Planning Officer: Mr F Gardner
Planning Application Ref: FP/68/20/T
Location: 33 Westmorland Drive, Felpham, PO22 8NA
Description of works: Fell 1no. oak tree
Reason given: Health and Safety (unstable from base)

REF 1

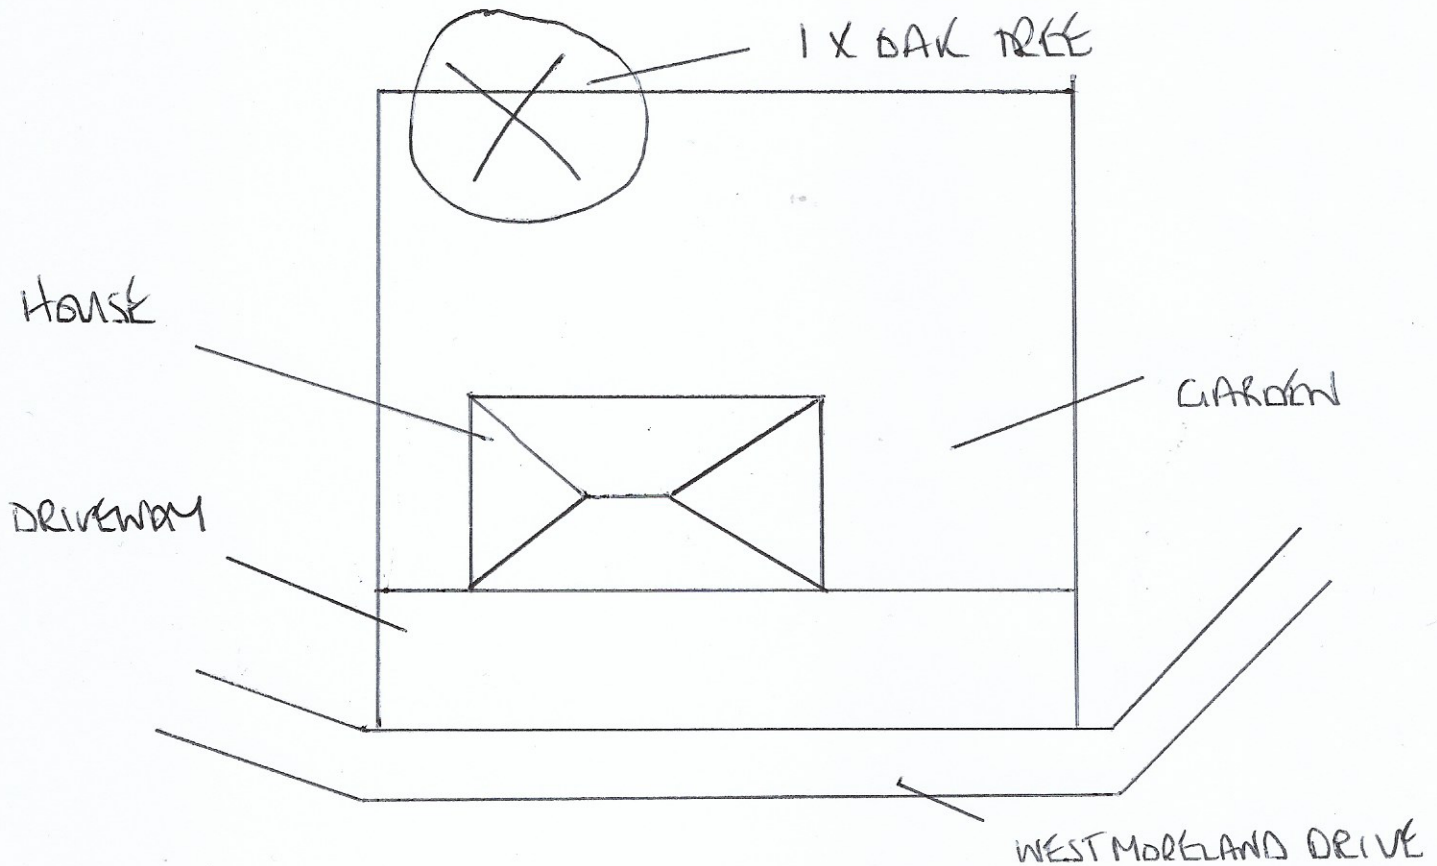
- From a distance this tree appears to be in a fine physiological state. It has recently been the subject of extensive crown reduction pruning (April 2020), a reasonable and permitted response to the recent discovery of voids around the stem base, some evidence of associated decay and a pronounced lean so heavily weighted towards neighbouring residential property.

- During my own ground-level, non-invasive assessment of the tree, I observed no obvious sign of active, significant wood-decay fungi or recent ground disturbance to suggest a compromised root-plate. The surrounding reaction wood, ratio of apparently sound wood to open cavities in the main stem and healthy appearance of buttress roots *suggest* this tree is structurally sound at this time and does not present an unacceptable level of risk for its location. The significant lean of this tree is more likely to have arisen from the historic presence of a co-dominant stem or close companion tree; the loss of which has resulted in large decaying stem/buttress root fragments which observed for the first time understandably raise concern and warrant detailed assessment.

- Although the tree is likely to be structurally sound at this time, there is a potentially harmful disease affecting the bark on the underside of the main stem. Large areas are 'blown' and will eventually detach, with evidence of stem bleeding (black crust) between dead bark ribs. Anecdotal evidence suggests there may have been some upper crown decline on this same aspect, consistent with damaged vascular tissue.

- Despite the necessary recent pruning to reduce its dimensions and thus reduce loadbearing on an imperfect stem/root-plate, this tree can continue to provide a visual amenity to the surrounding area and significant ecological and environmental value. This while being subject to repeat crown reduction work ideally on a 5-7year cycle and subject to the extent of growth since the last operation.
- The tree work proposed in the application has not been justified on arboricultural grounds. The tree is a significant feature in the local landscape and appears to be in adequately sound and healthy condition. The tree work proposed in the application would result in undue detriment to the local landscape and visual amenities of the locality.

- I recommend **REFUSAL** for this application.
